30 September 2020

**SSD-10414 - MIXED USE DEVELOPMENT, LOT: 112 DP: 1022614 LOT: 1-4 DP: 1191104, 8-16
WATT STREET GOSFORD**

On 7 September 2020 TfNSW accepted the referral by the Department of Planning, Industry & Environment (DPIE) through the Planning Portal regarding the abovementioned application (Development Application). DPIE referred the Development Application to TfNSW for comment. This letter is a submission in response to that referral.

Figure 2: Extract of Concept Site Plan

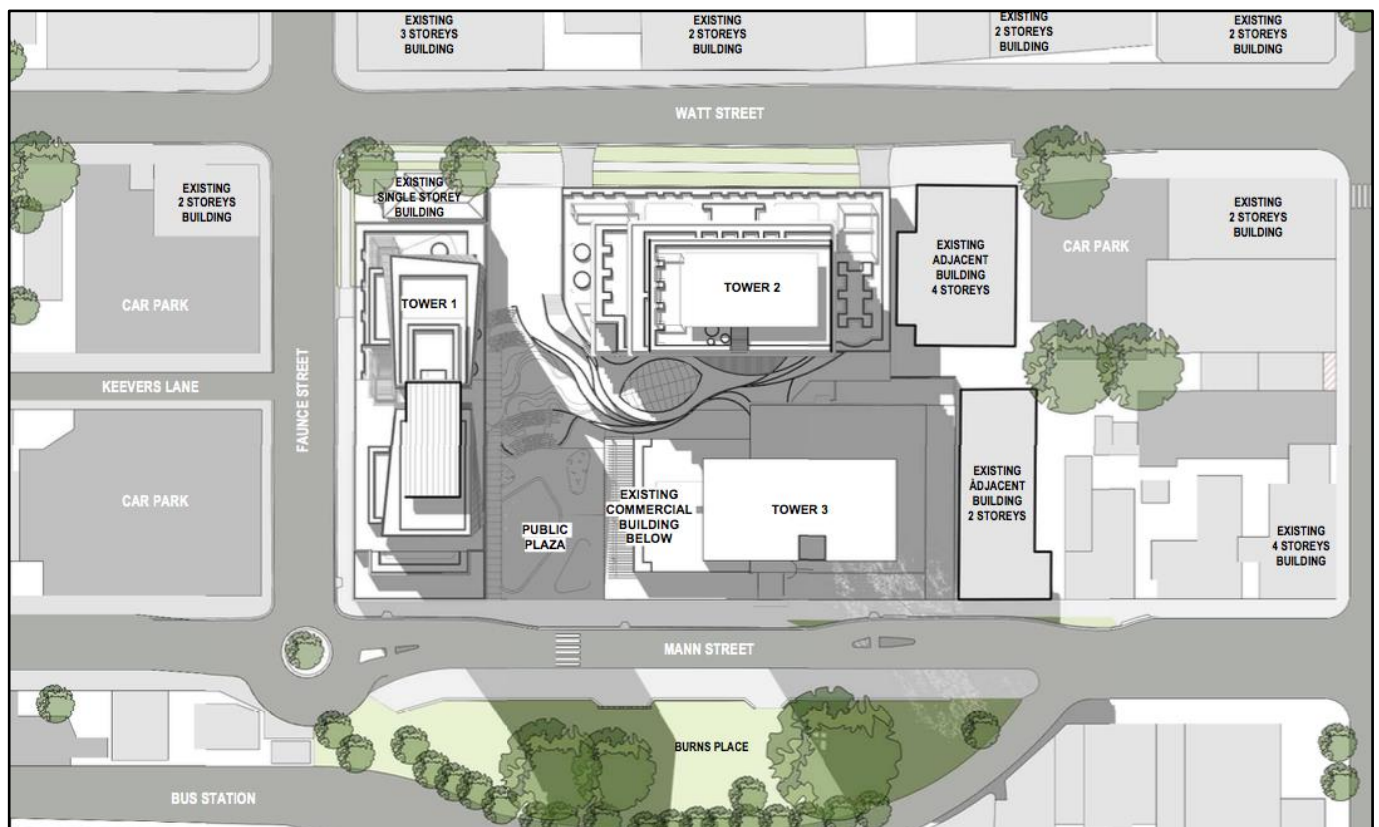
- The proposal involves removal of existing overhead pedestrian bridge across Mann Street and installation of a new at-grade pedestrian (zebra) crossing aligned with the internal plaza. Considering the traffic volume and history of pedestrian crashes on Mann Street, TfNSW does not support proposed pedestrian (zebra) crossing. TfNSW supports installation of a signalised

midblock crossing. The signalized crossing is considered a safer crossing facility and would also assist in reducing traffic flow interruptions that would otherwise occur with proposed pedestrian (zebra) crossing.

TfNSW recommends that existing two pedestrian refuges on Mann Street between Faunce Street and Burns Crescent are removed in association with the recommended signalised midblock marked foot crossing to encourage pedestrians to use the new safer crossing facility.

- Considering the above recommendation, the revised TIA should model a signalised midblock crossing on Mann Street to determine the traffic impact of removing the overhead pedestrian bridge.
- The proposed staging plan appears to indicate provision of a pedestrian (zebra) crossing on Faunce Street north of the Mann Street roundabout. TfNSW highlights that the location of any new pedestrian (zebra) crossing needs to meet TfNSW traffic and pedestrian volume warrants and is subject to the support of local traffic committee. It is recommended that the location provides a pedestrian refuge, similar to the other two approaches of the roundabout, which would facilitate staged crossing of Faunce Street.

1 LEVEL 1
aaa 1:500

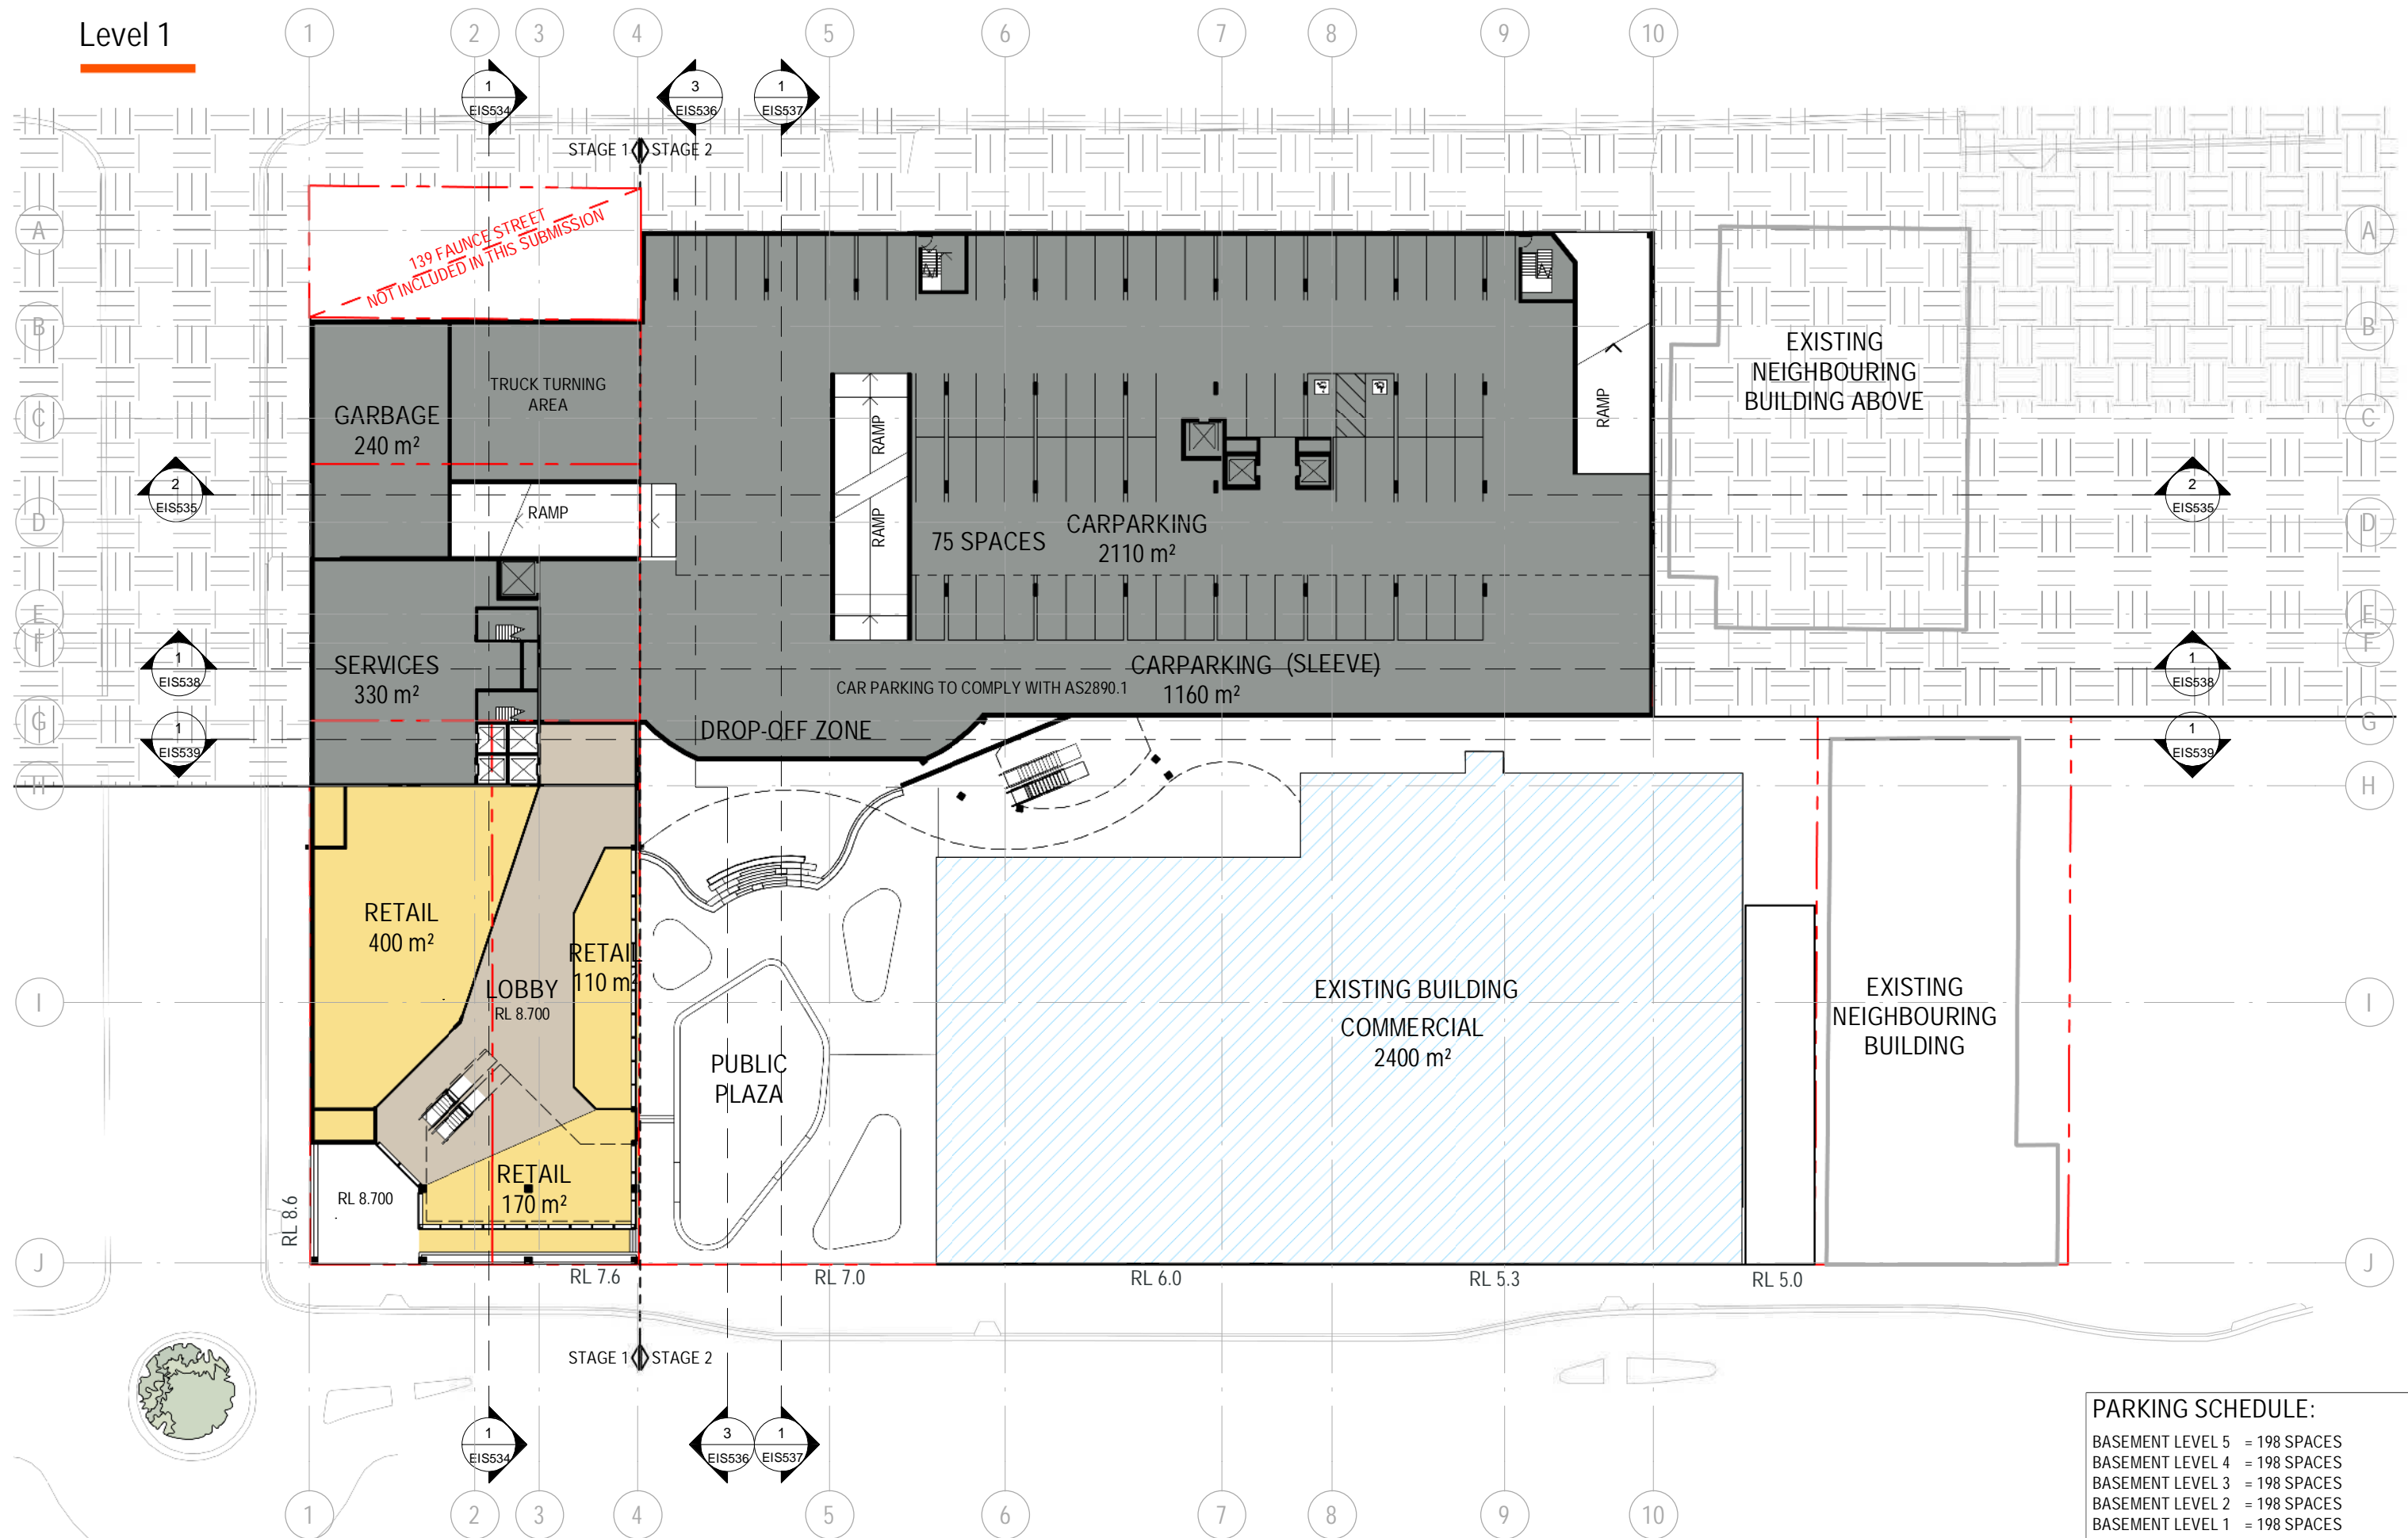
- It is unclear how many parking and service bays will be provided within individual stages of the development. TfNSW considers that sufficient parking and service bays should be provided within individual stages of the development to meet requisite parking demand on standalone basis.
